Your ref: 3/2025/0536  
Our ref: 3/2025/0536/HDC/KW  
Date: 04 August 2025

**Location:** Dale Hey Bungalow Preston Road Ribchester PR3 3XL  
**Proposal:** Part retrospective outline planning permission to demolish the existing bungalow and proposed new detached self-build 4/5 bedroom house with access applied for (all other matters reserved).  
**Grid Ref:** 364085 436062

Lancashire County Council acting as the Local Highway Authority (LHA) does not consider that the application as submitted fully assesses the highway impact of the proposed development and further information is required as set out in this response.

Dwng No. **A4578-PL03** Rev. **B**

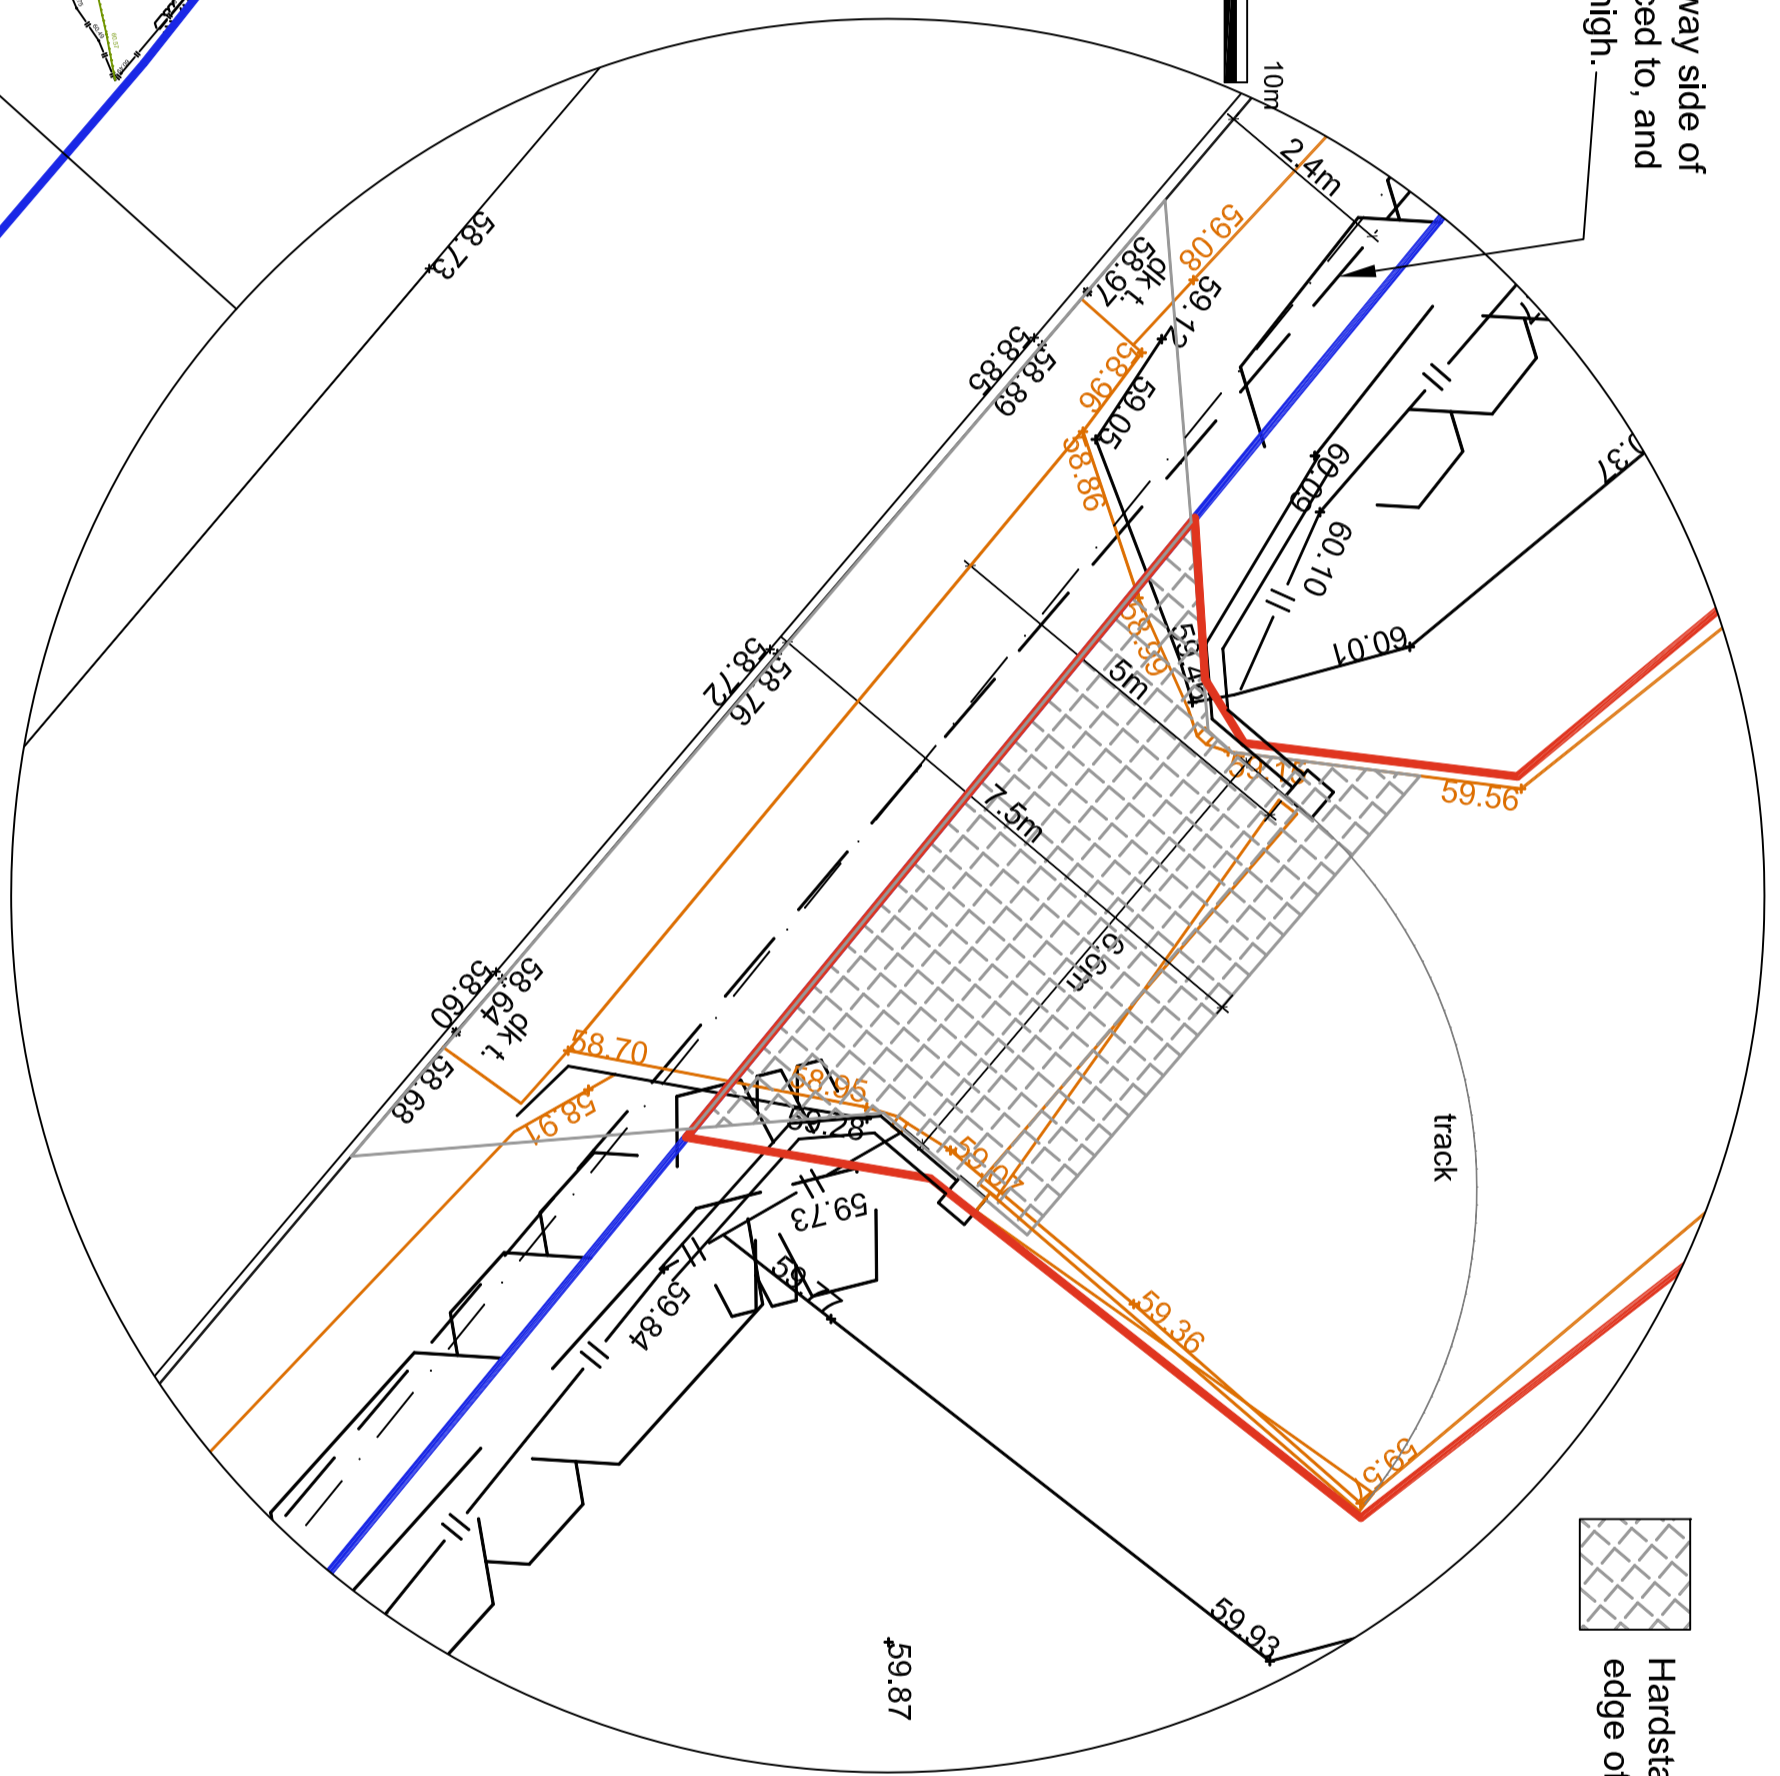
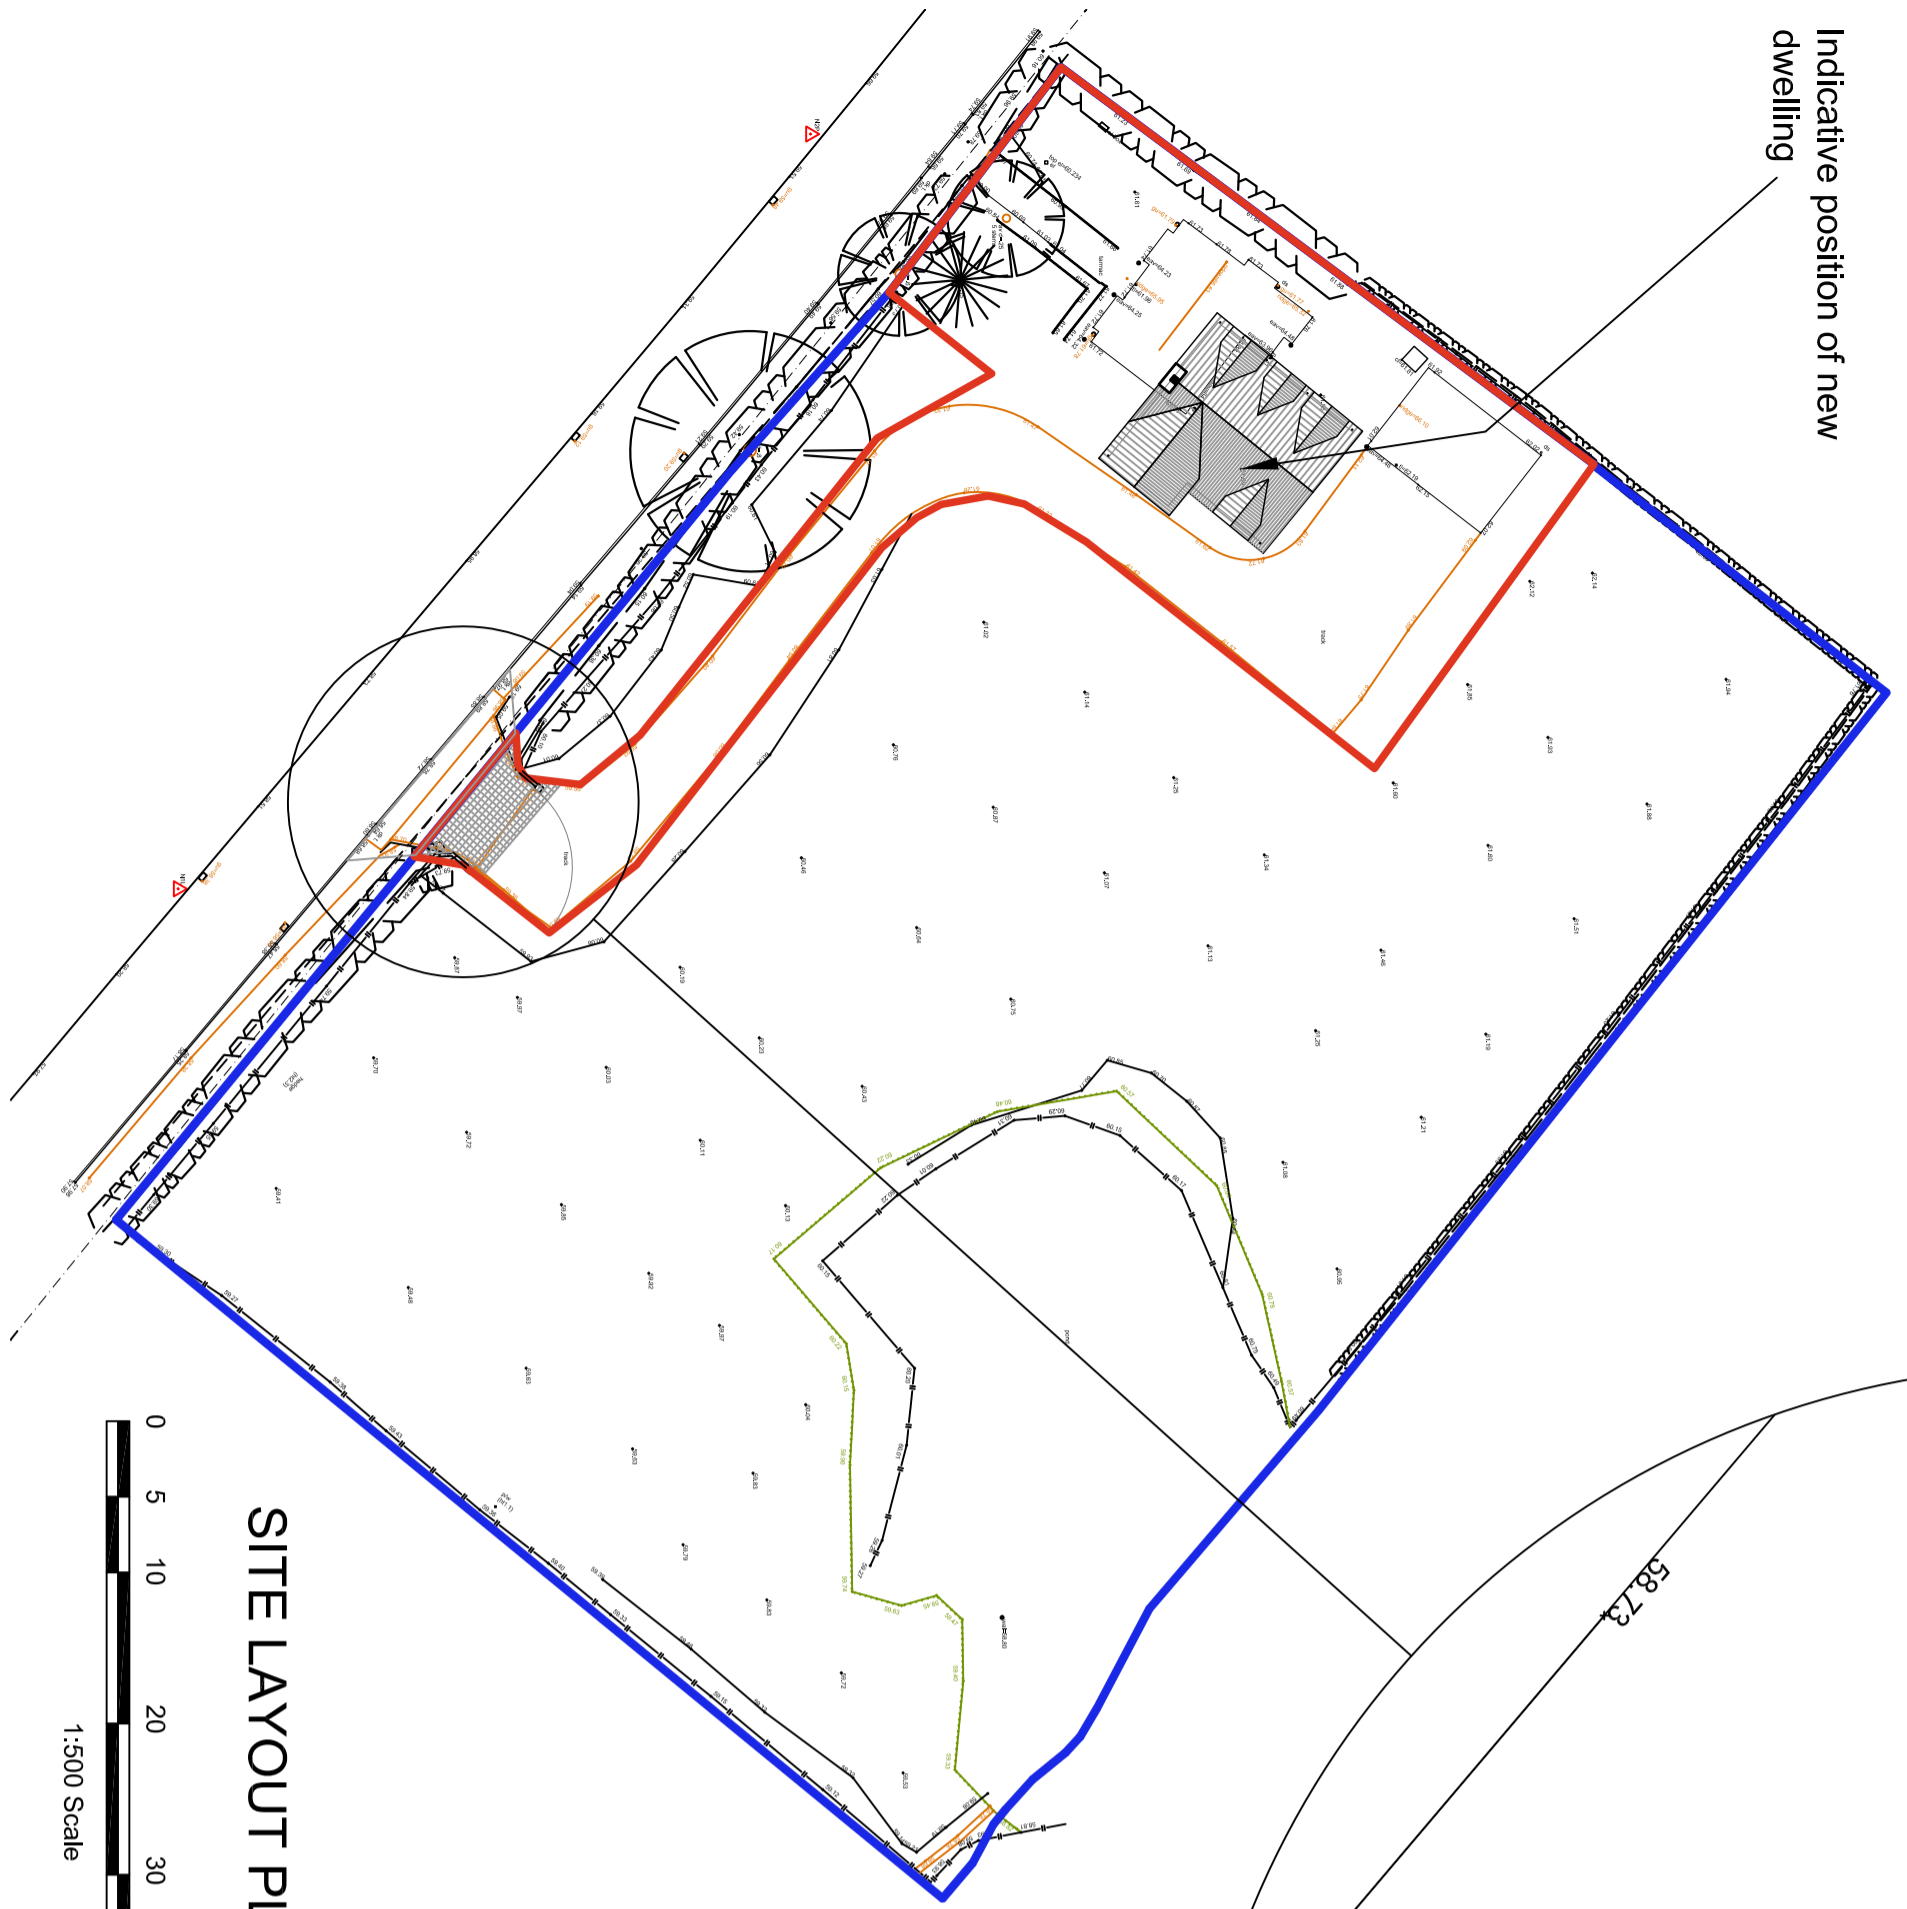
The applicant shall ensure that the access is hard surfaced for at least 5m into the site behind the highway boundary, which in this case should be behind the back of the existing verge. The Proposed New Access plan, drawing A4578-PL03, currently shows hard standing for approximately 4.4m into the site from the highway boundary. This should be revised on an amended plan.

The proposed gates are also situated too close to the highway boundary and should be situated at least 5m behind the highway, maintained at public expenses, which in this case includes the carriageway and verge. Further setting back the gate will allow vehicles to fully clear the highway before operating the gate, allowing for a safe and suitable access. As the gate needs to be repositioned, the internal driveway layout may require slight amendments to allow the gates to open, which should be shown on an amended plan.

- Extending the hard surfacing to a minimum of 5m behind the highway boundary.
- Repositioning the proposed gates to be set back at least 5m from the highway maintained at public expense.
- Adjusting the internal driveway layout to accommodate the revised gate position.
